**From:** Rebekah Morgan  
**Sent:** 14 December 2023 16:48  
**To:** Rebekah Morgan  
**Subject:** FW: 23/00390/F: EP Barrus, Launton Road, Bicester

Applicant's response to drainage objection

Thus, on this basis, and with reference to the *LLFA comments*, we would make the following observations.

APPENDIX H

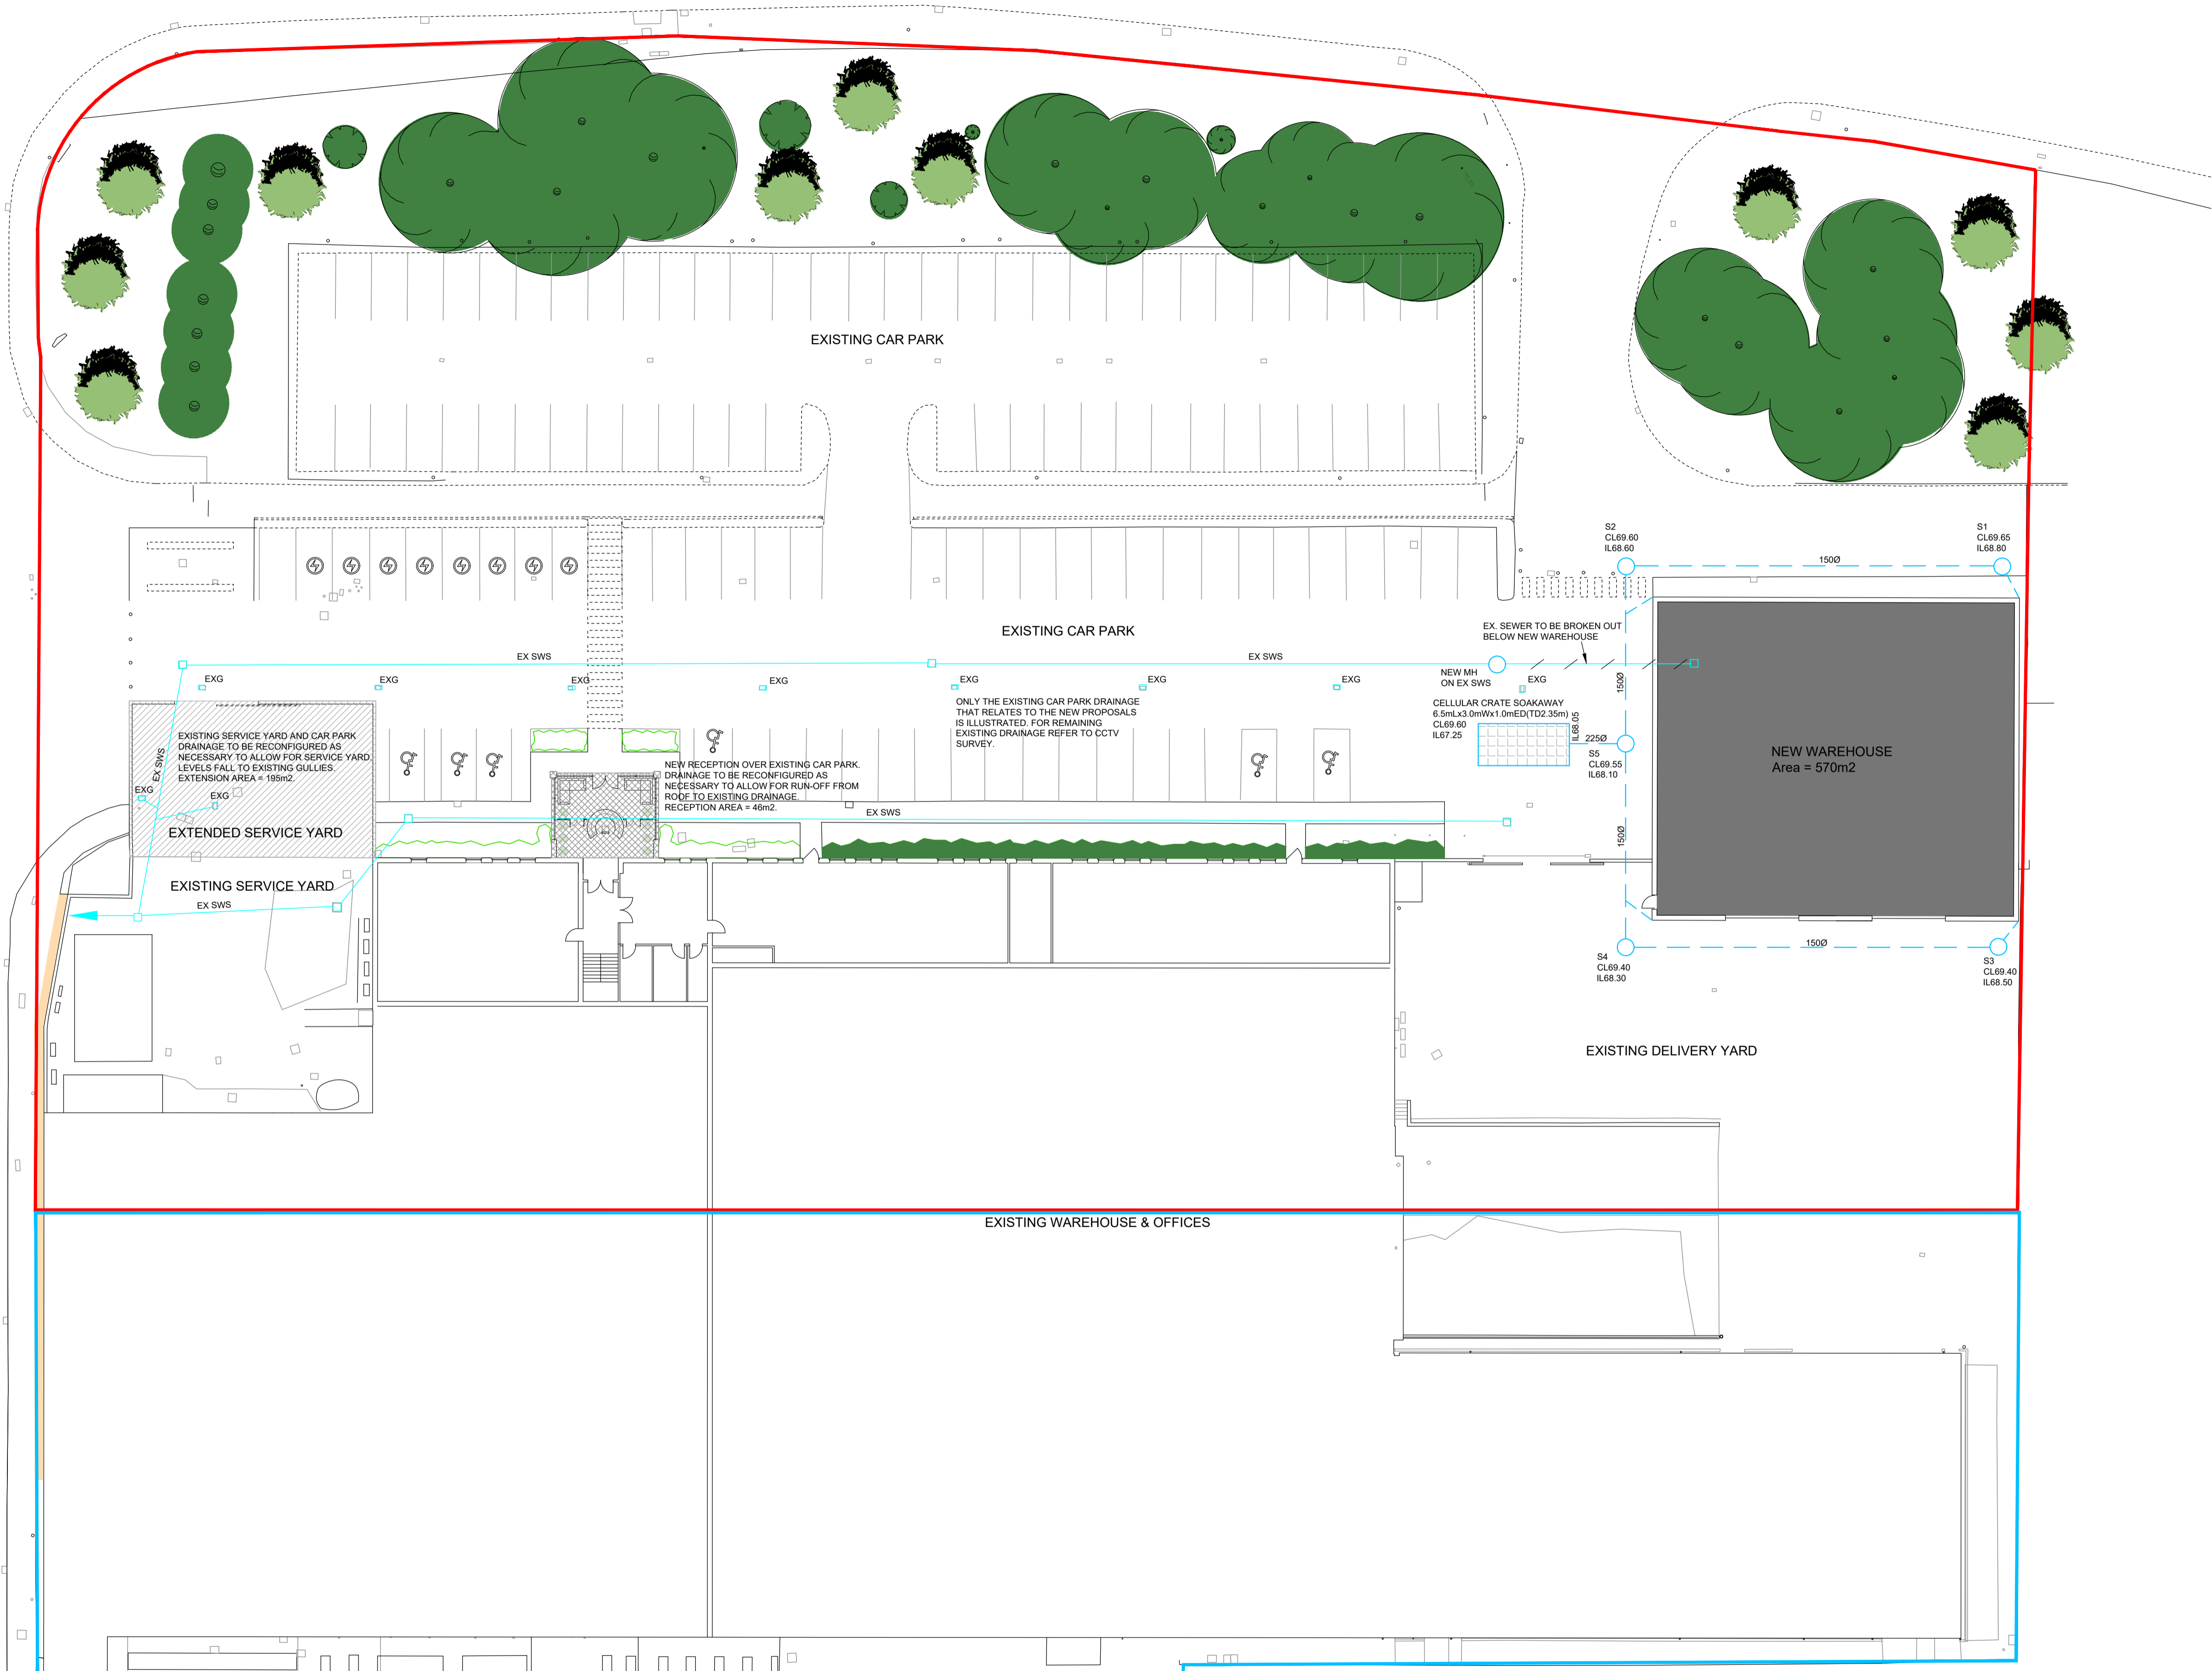
*The drainage strategy is unclear in some areas. The extended service yard and parking area reception area, how this area will be draining and being picked up by the existing drainage is unclear. Manhole size to be included for the new manhole and pipe gradients to be shown for the proposed drainage.*

*The existing sewer that will be broken out next to the new warehouse, the new connection is not demonstrated and how the drainage will outfall from the new manhole. All proposals needs to be clear and demonstrated on the drainage drawing.*

*Provide remedial works on the drainage strategy drawing for the existing drainage infrastructure.*

- *Drainage strategy drawing to be provided.*  
A drainage strategy drawing is included within Appendix H of the Drainage Statement. This illustrates the new surface water drainage for the proposed warehouse, and the existing drainage network that currently drains the hard paved areas which are to be reconfigured, with no increase in the impermeable area post development.

- *Remedial works to be identified on the drainage drawing.*  
The relevant notation is included on the drainage drawing, which is to allow some flexibility in the construction process, and where necessary, will form part of a Building Regulation process / application post planning consent. It should be noted however, that the existing drainage will be used to drain the hard paved areas that are being reconfigured, with no increase in impermeable area. The applicant has provided detailed information of the existing drainage for the LLFA, which includes CCTV drainage surveys within Appendix D of the DS.

- *Confirm the capacity of the existing drainage infrastructure taking proposed areas.*  
There are no additional flows entering the existing drainage system. The reconfiguring of hard paved areas e.g. car park to service yard, does not increase the impermeable area contributing to the drainage system. The only new additional impermeable area is from the proposed warehouse, which drains to a new soakaway and does not enter the existing drainage system.

It should also be acknowledged by the LLFA that there will be a small reduction of existing flows to the drainage system. This is due to the proposed warehouse replacing a small area of the delivery yard to the northeast, which will reduce the contributing impermeable area to the existing drainage network due to the proposed warehouse fully draining to a new soakaway. Thus, a betterment to the existing drainage system with a small reduction in run-off. This is clearly illustrated on the drainage drawing and the existing and proposed development layouts.
